WEST SUSSEX COUNTY COUNCIL CONSULTATION

TO:	Arun District Council FAO: Simon Davis
FROM:	WSCC - Highways Authority
DATE:	18 th June 2021
LOCATION:	Land At Wings Nursery Lidsey Road Woodgate PO20 3SU
SUBJECT:	AL/20/21/PL Demolition of Wings House & erection of 71 No. replacement dwellings (70 net new dwellings), access arrangements, sustainable drainage measures, public open space, landscaping & all other associated works (resubmission following AL/46/20/PL). This application is a Departure from the Development Plan. Further information received.
DATE OF SITE VISIT:	n/a (visited as part of the assessment undertaken for previous proposals AL/117/17/OUT, AL/32/19/OUT and AL/46/20/PL).
RECOMMENDATION:	No objection
S106 CONTRIBUTION TOTAL:	TBA

Drawing No.
2019-6115-002

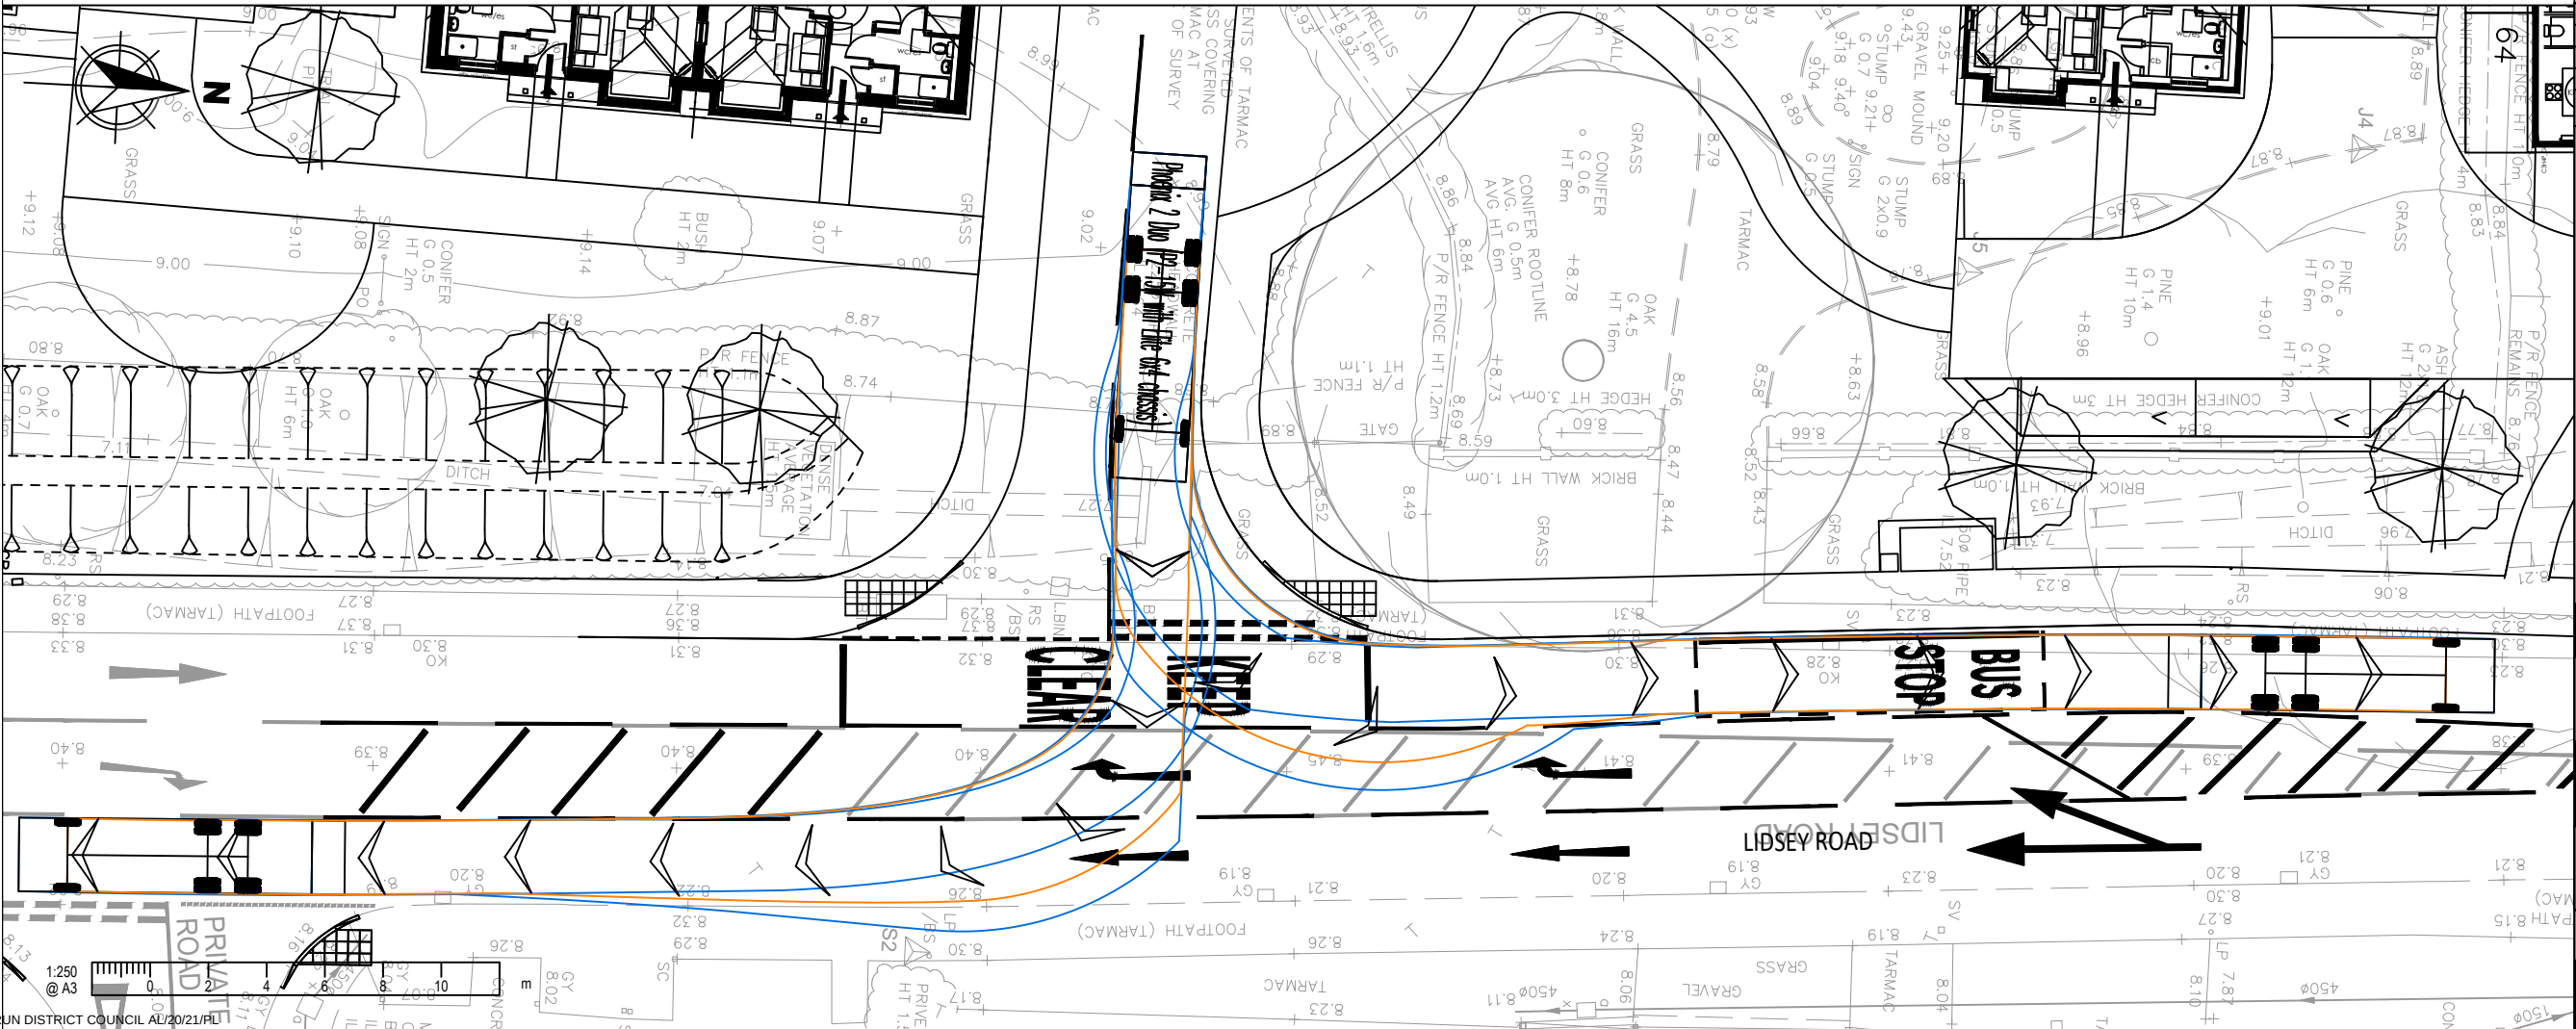
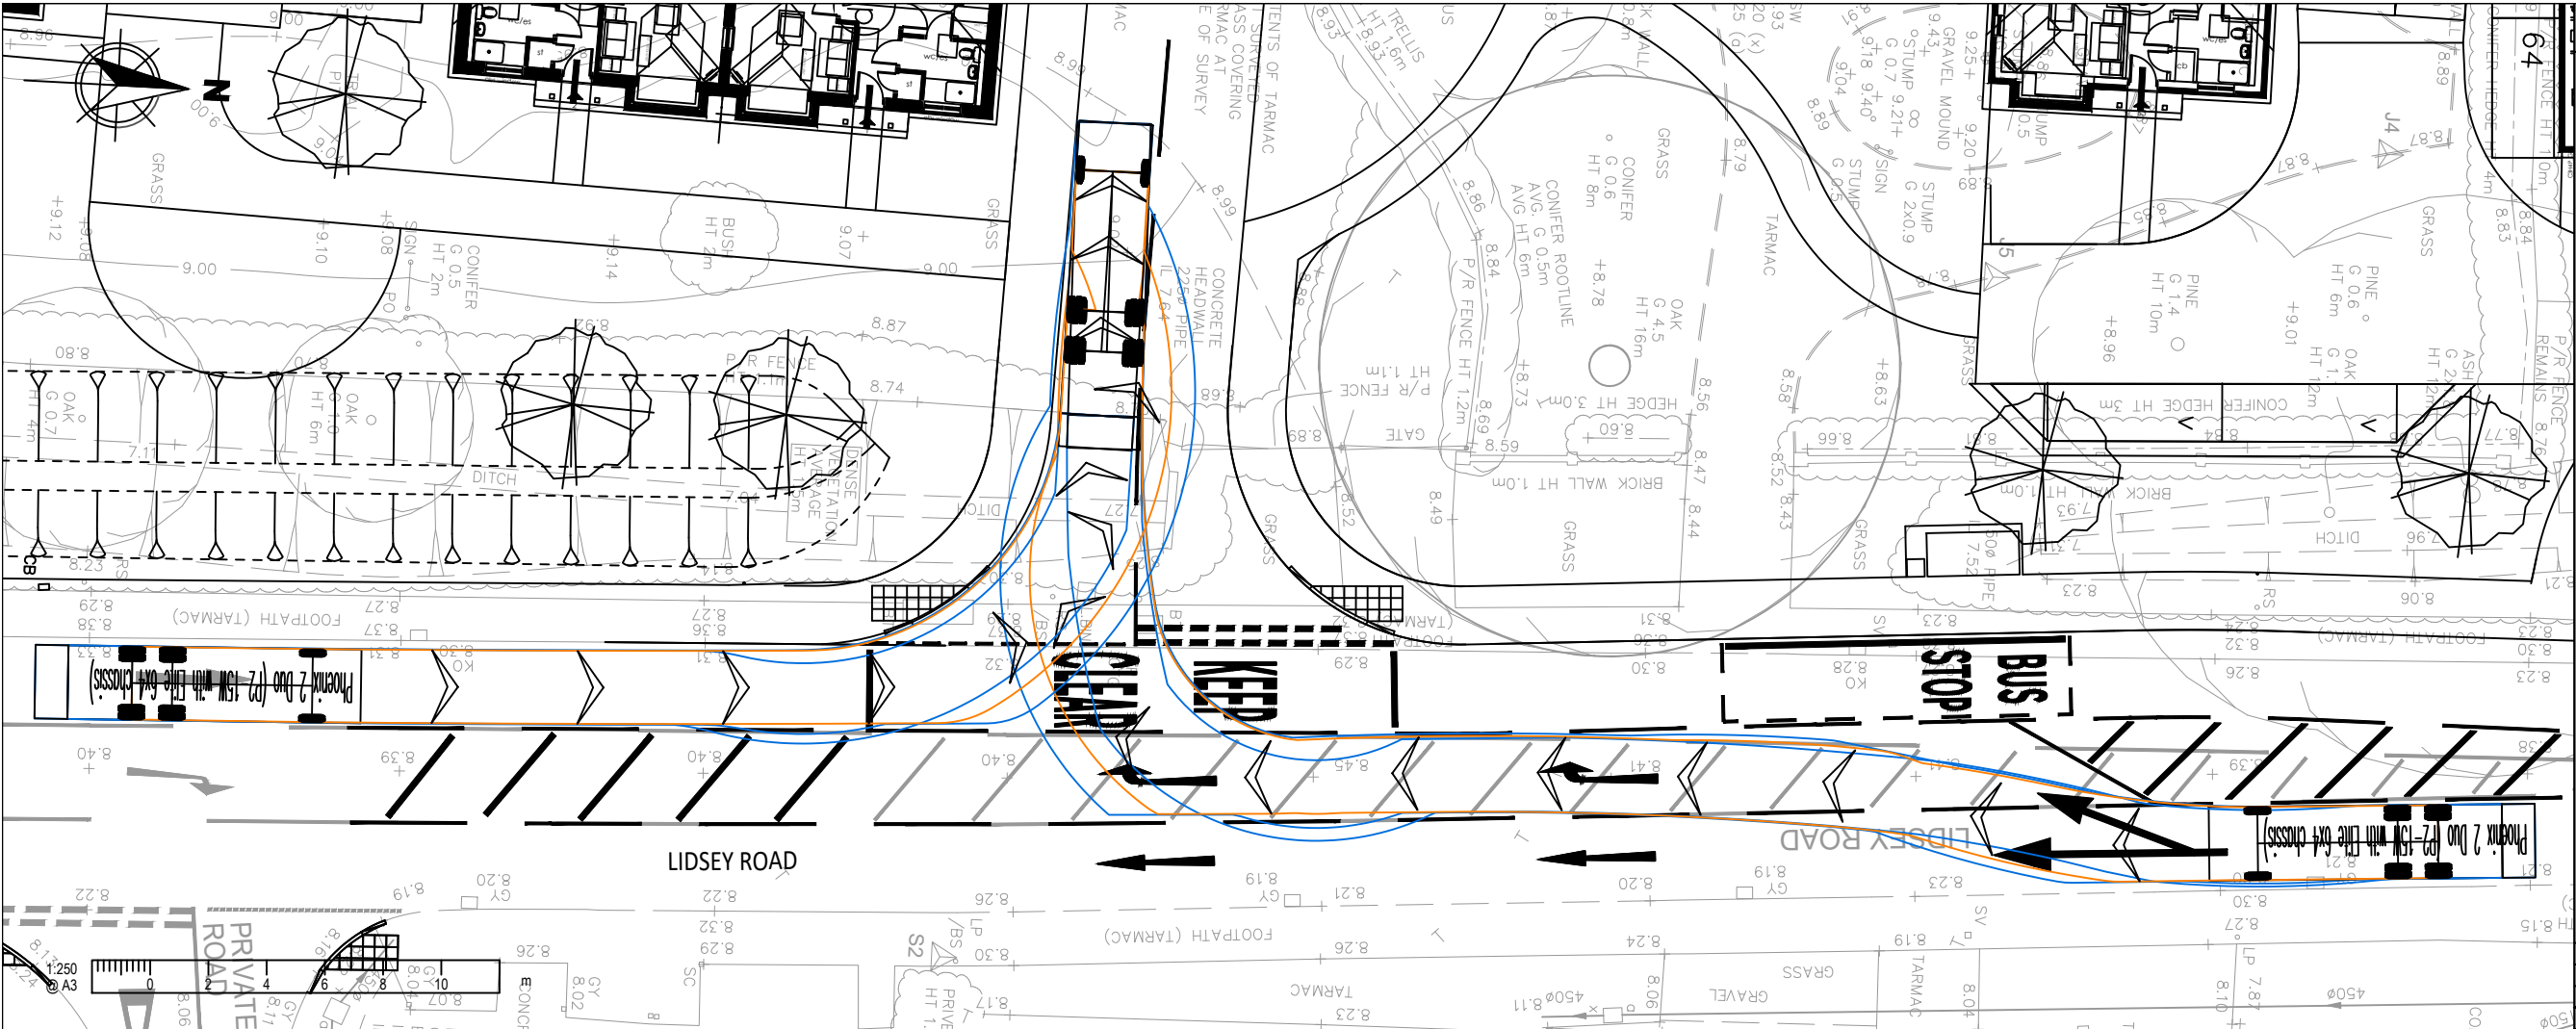
1. Tracking diagram for a refuse vehicle adjacent to plots 63 and 64. *The reply from the consultants says that refuse collection for these units would be undertaken from Lidsey Road as per existing properties in the locale. As such, they have*

7. Replies to all bullet points under sub-heading 'internal layout and parking'. *Please see below (previous comments in black text):*
 - Turning for a refuse vehicle is not demonstrated adjacent to plots 63 and 64. *Please see comments under point 1 above.* Furthermore, another area of concern is the width of the access road serving plots 5-10. This appears to be 4.1m wide which is easily blocked if a vehicle were to park on it. This should be widened to a minimum of 4.8m wide. *This is still shown measuring 4.1m wide. However,*

demonstrated that bin carry-distances for refuse collectors and residents are compliant with Manual for Streets as demonstrated in Drawing 2020-6115-008.
